22 June 2012

Our Ref: 2012/163169

Your Ref: MP 09\_0145

**Environmental Assessment for Macdonaldtown Gasworks Remediation Project  
(MP09\_0145)**

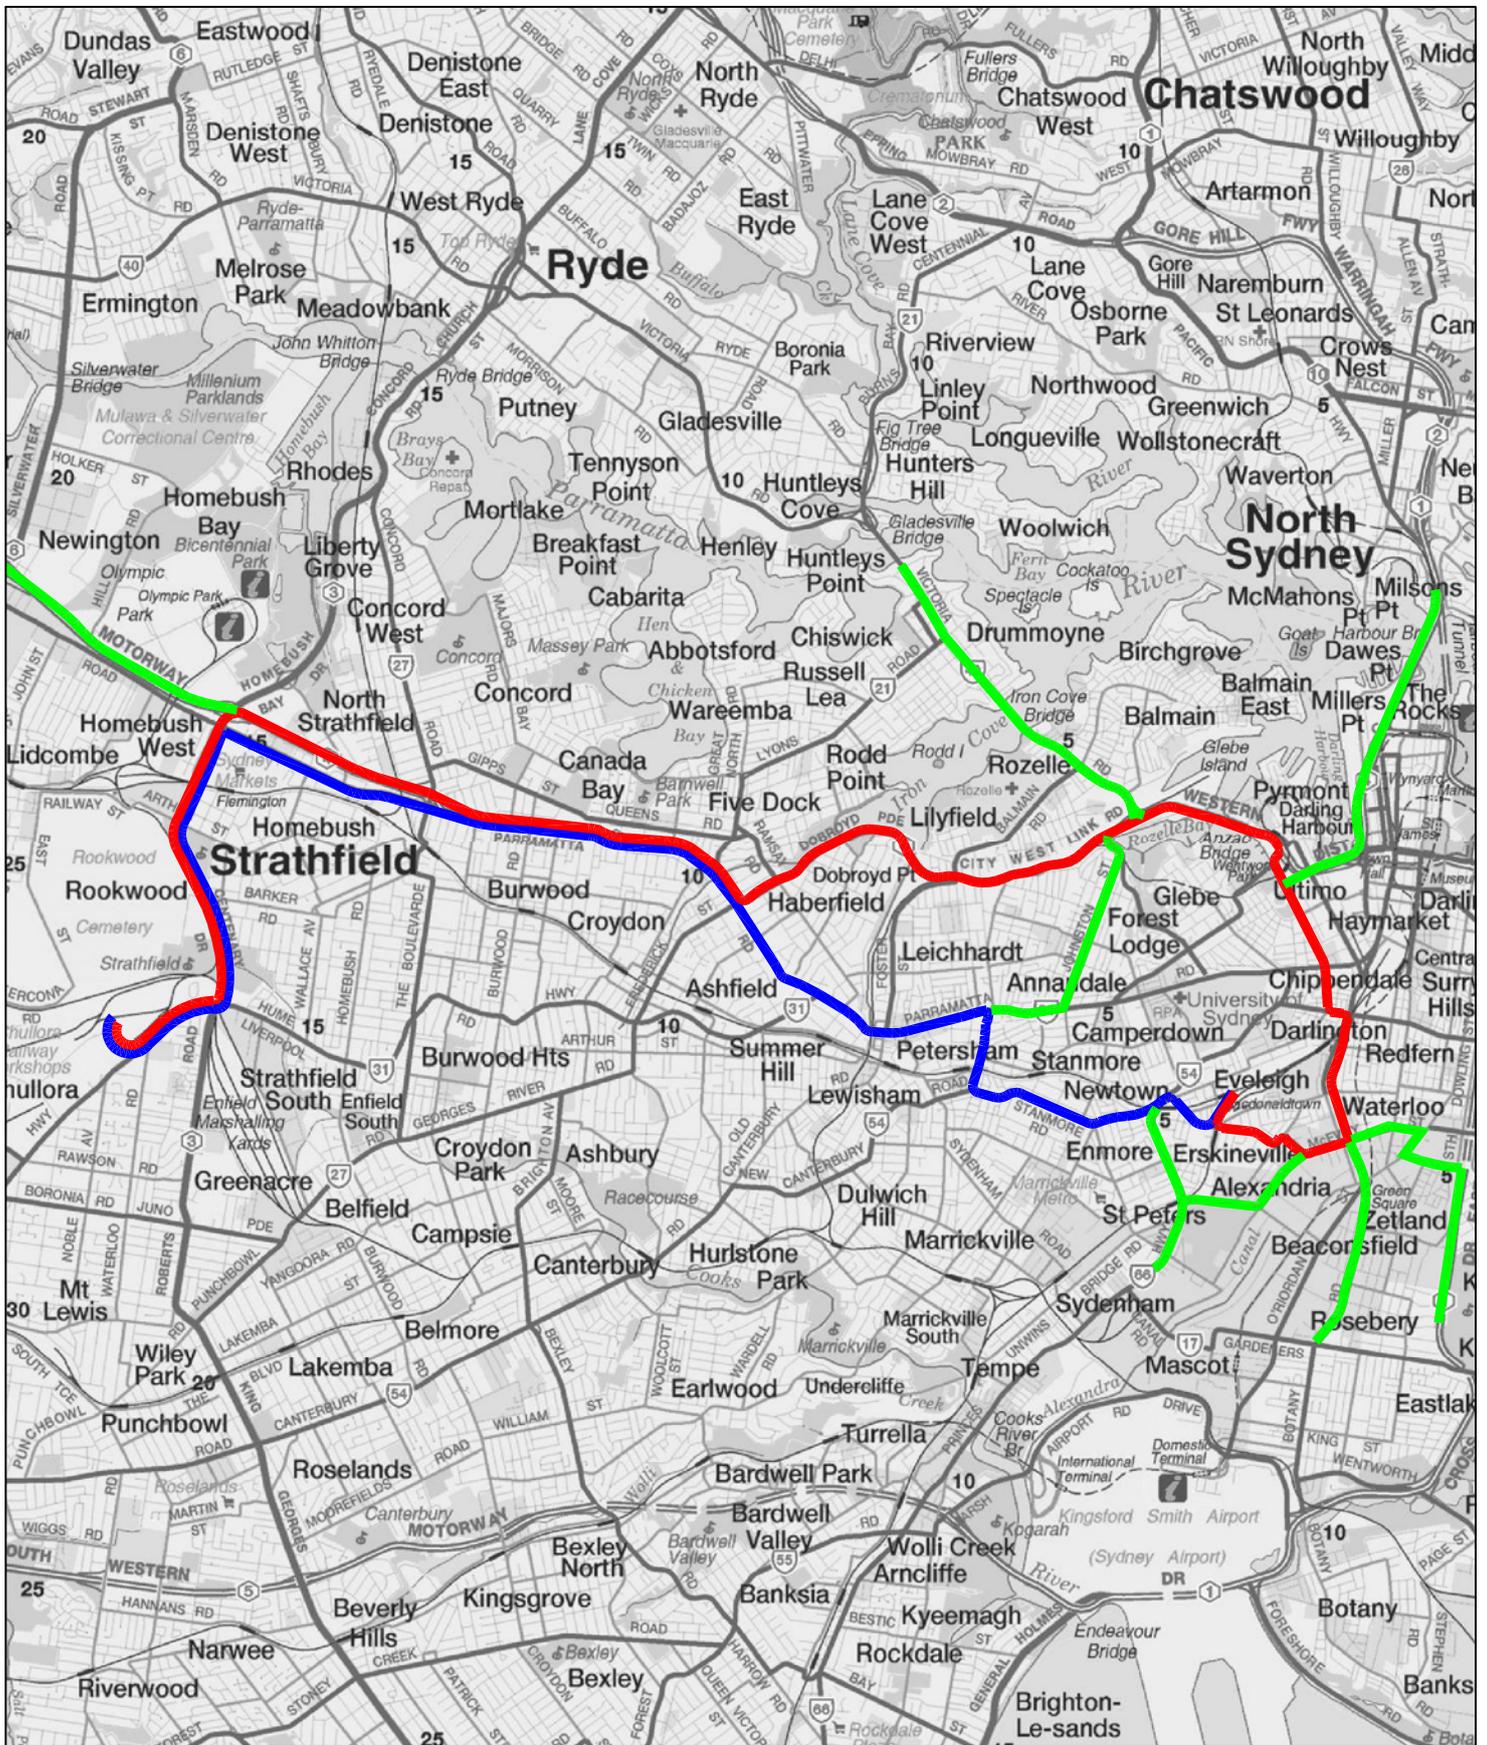
The Traffic and Pedestrian Management Plan prepared by Transport and Traffic Planning Associates dated September 2010 is to be amended to include the City's Standard Requirements as Appendix B of the plan and includes the following:

- (a) All vehicles including trucks relating to the MacDonalddtown Gasworks Remediation site must access the site via an existing driveway on the northern side of Swanson Street, west of the railway line. Truck routes to and from the site must use state and regional roads as follows:

- (i) Arriving to the site: via Parramatta Road, Stanmore Road, King Street, Wilson Street, Erskineville Road, Swanson Street and left to the site.
  - (ii) Departing the site: left only to Swanson Street, Copeland Street, Mitchell Road, Fountain Street, McEvoy Street, Botany Road, Cleveland Street Abercrombie Street, Wattle Street, Pyrmont Bridge Road, Anzac Bridge to City West Link Rd to Chullora.

- (iii) Construction vehicles including trucks must not use residential streets within City of Sydney's Local Government Area.
- (b) The approved truck routes plan shall form part of the contract and must be distributed to all truck drivers.
